# CITY OF ALBUQUERQUE

**Re: BJ Restaurant- Winrock Mall, Grading Plan for Building Permit  
Engineer's Stamp date 5-23-2012 (J19/D058A)**

TITLE:				BJ'S BUILDING PERMIT GRADING PLAN				
Design Review Committee		City Engineer		Last Update	Mo./Day/Yr.		Mo./Day/Yr.	
City Project No.			Zone Map No.		Sheet		Of	
			J-10-Z		C102

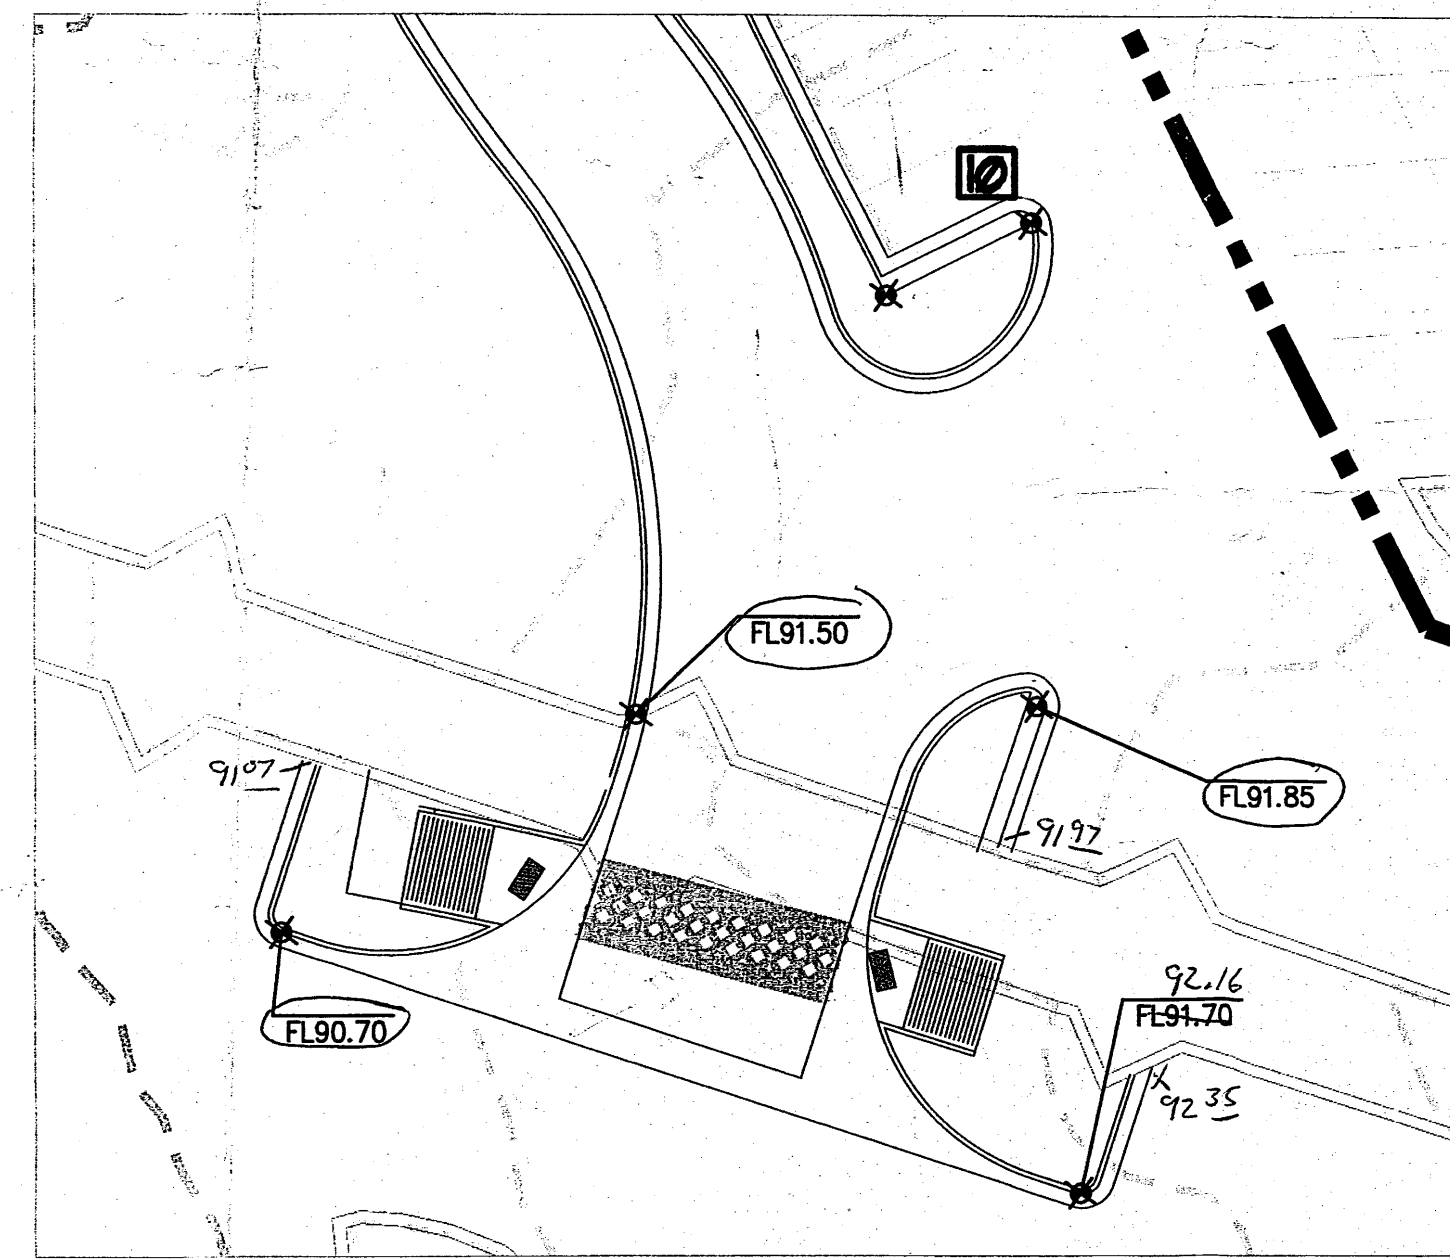
Per the DPM Chapter 22 Section 9, runoff from the trash enclosure pad is required to drain to the sanitary sewer. Per our telephone discussion, this will be shown on the utility plan for Building Permit, and must be included in your Engineer's Certification for Certificate of Occupancy.

Prior to Certificate of Occupancy release, provide this office with an Engineer's Certification per the DPM checklist, including the as-built trash enclosure drainage.
